M25 junction 28 improvement scheme

TR010029

9.73 Applicant's response to the Gardens of Peace's written summary of hearings

April 2021

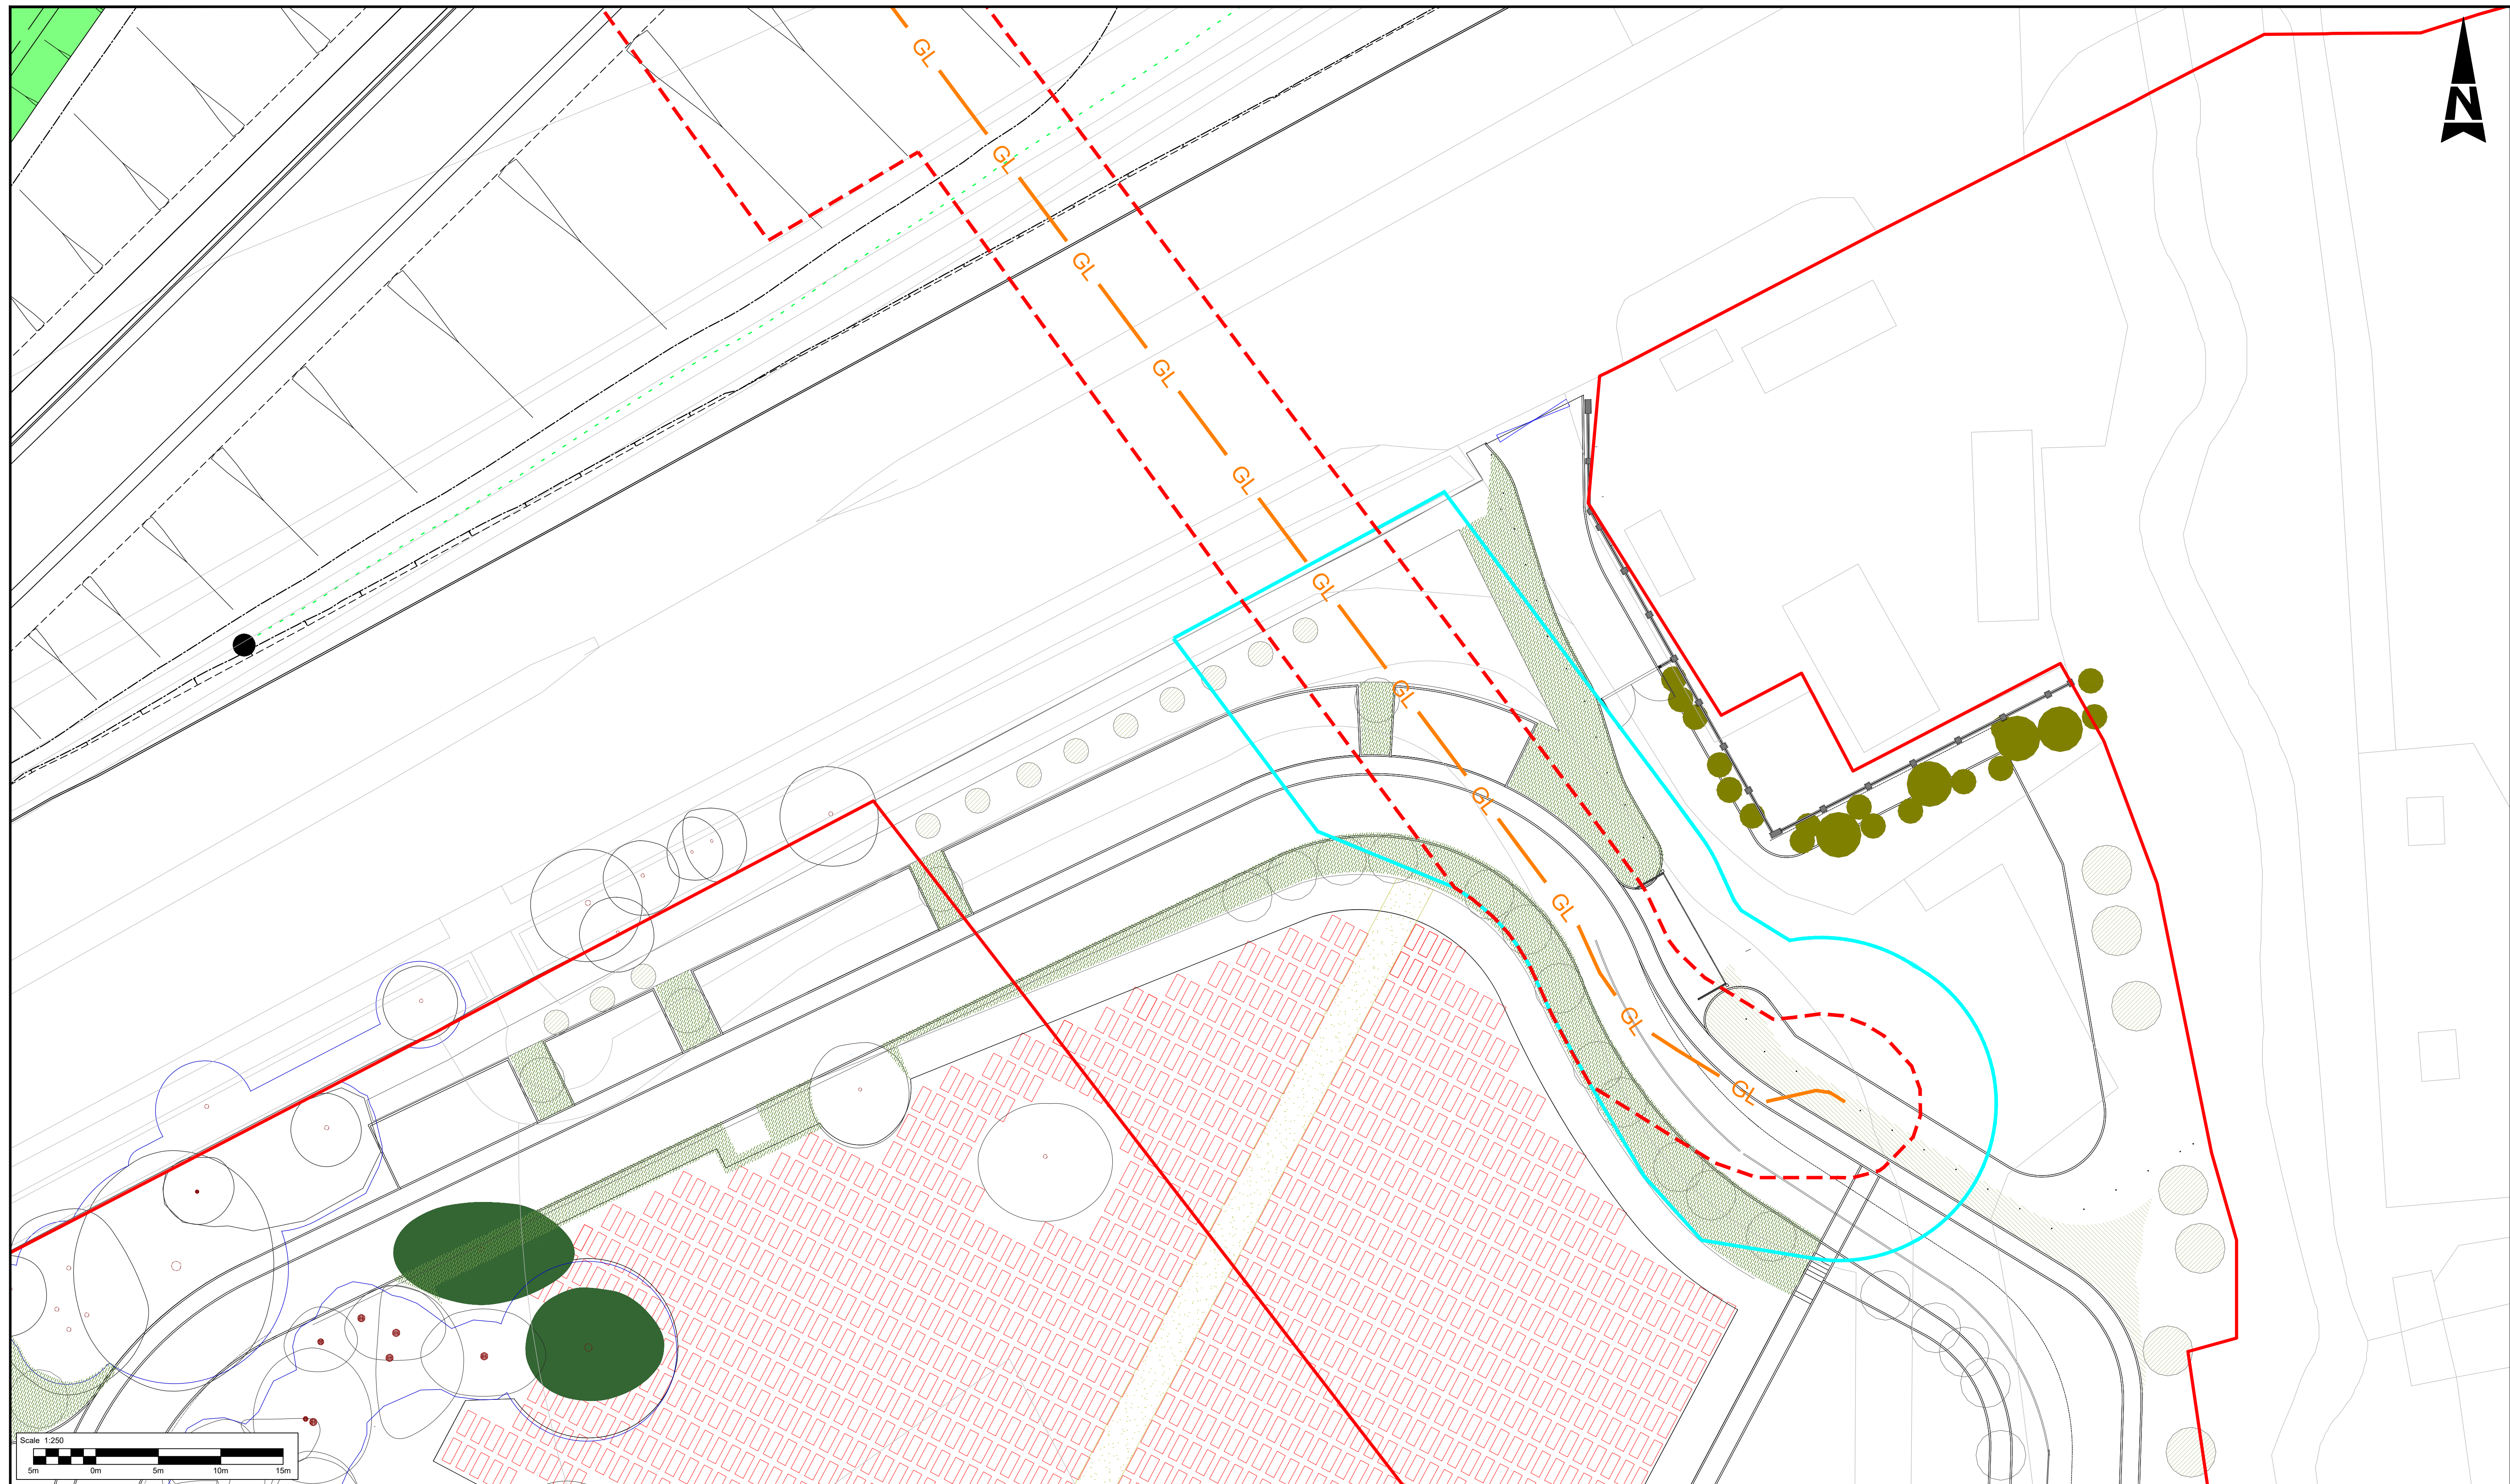
Response reference:	Representation Issue	Highways England Response
		<p>There is also a commitment in the Statement of Common Ground with Cadent Gas to ensure that burial plots will not be lost (based on the latest burial layout provided by the Trustees on 17 March 2021). This commitment is set out in, point 1.7 of the draft SoCG between Cadent and Highways England (REP1- 009).</p>
REP4-034-18	<p>vii) Easement - Gardens of Peace requested a draft Easement document in August 2020 which would outline the land use restrictions in light of the gas main. The easement was provided on 15th March 2021. This will be reviewed by Gardens of Peace to ensure it does not prohibit it from undertaking the intended use of the land with Plot 1/8 (although this is unlikely as Highways England had confirmed in its response to Gardens of Peace's Written Questions that there "will be no future land restrictions over Plot 1/8" (see TR010029/EXAM/9.36 - REP2- 029-45)).</p>	<p>For the avoidance of doubt the existence of the gas main ought not prevent the Trustees operating the cemetery as intended. Plainly there are some limitations upon what could be built or done in the vicinity of the gas pipeline. The same applies to the existing gas pipeline. As outlined in REP4-034-17 above, the Cadent easement has reduced below the 6.1m half width where the pipeline is closest to the proposed burial plots. And the Plot 1/8 width similarly reduced to avoid a conflict however, there is still space for a full 12.2m easement width within Plot 1/8.</p>
